Harnett County Government Complex  
307 Cornelius Harnett Boulevard  
Lillington, NC 27546

April 25, 2011

**Re: Status of Improvement Permit Application HTE # 11-5-26393**

# Plot Plan

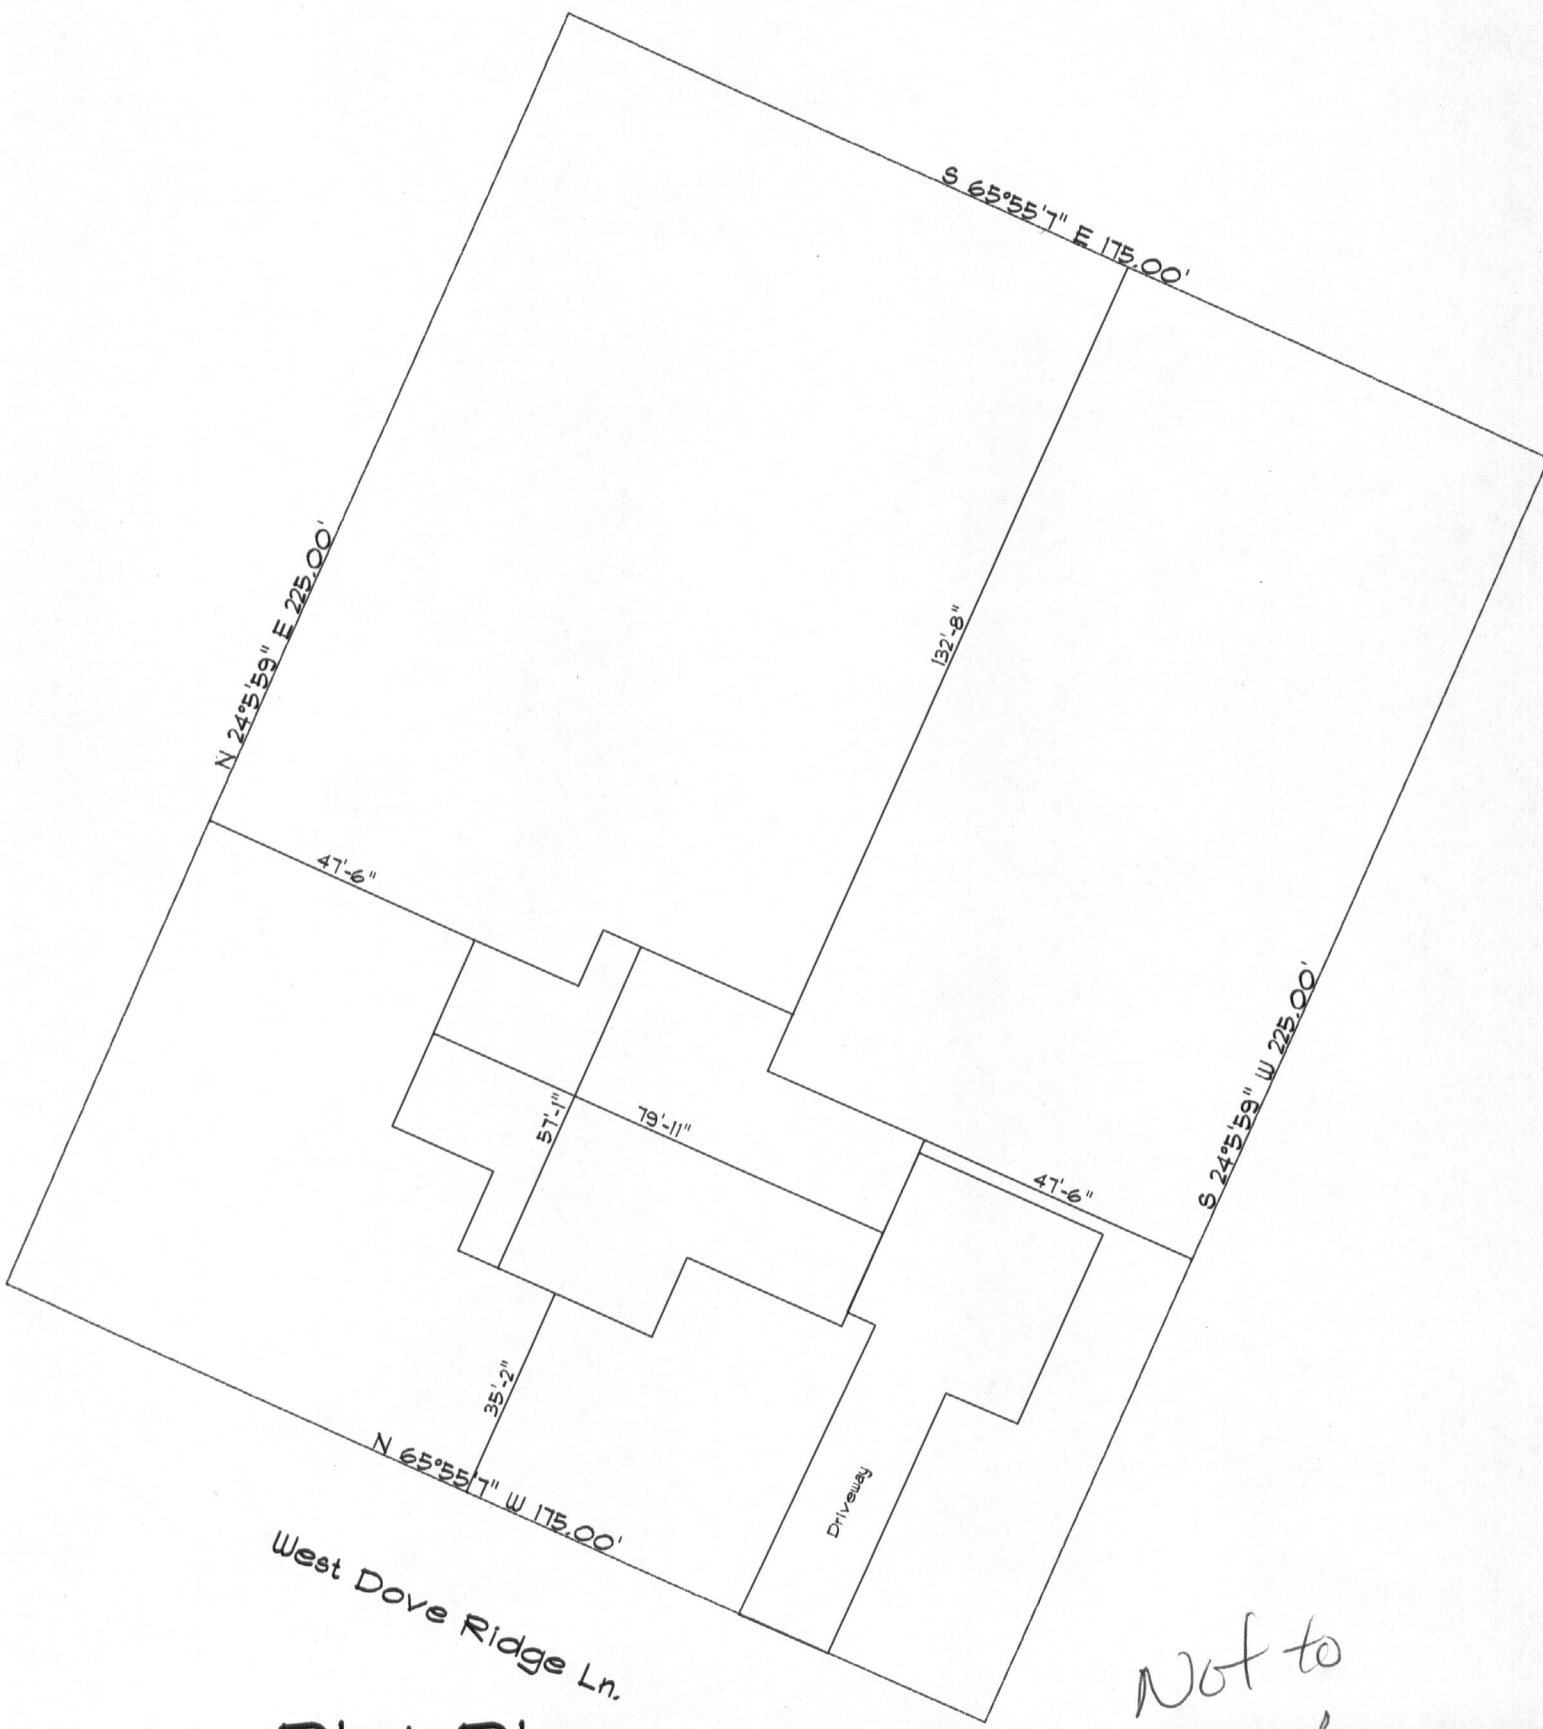
- 1. Use pink flags to mark property lines. All irons that are set by surveyor need to be visible. (*\$25.00 fee incurred*)
- 2. Use orange flags to mark house corners. **Did not match site plan** (*\$25.00 fee incurred*)
- 3. Directions not clear to property (*\$25.00 fee incurred*)
- 4. Property needs only brush or vegetation removed
- 5. Backhoe pits required
- 6. Other-

Your application will be put on hold until the selected items above have been addressed.

When completed please contact 910-893-7547 to confirm that the items mentioned have been corrected, we will then reschedule your property for evaluation.
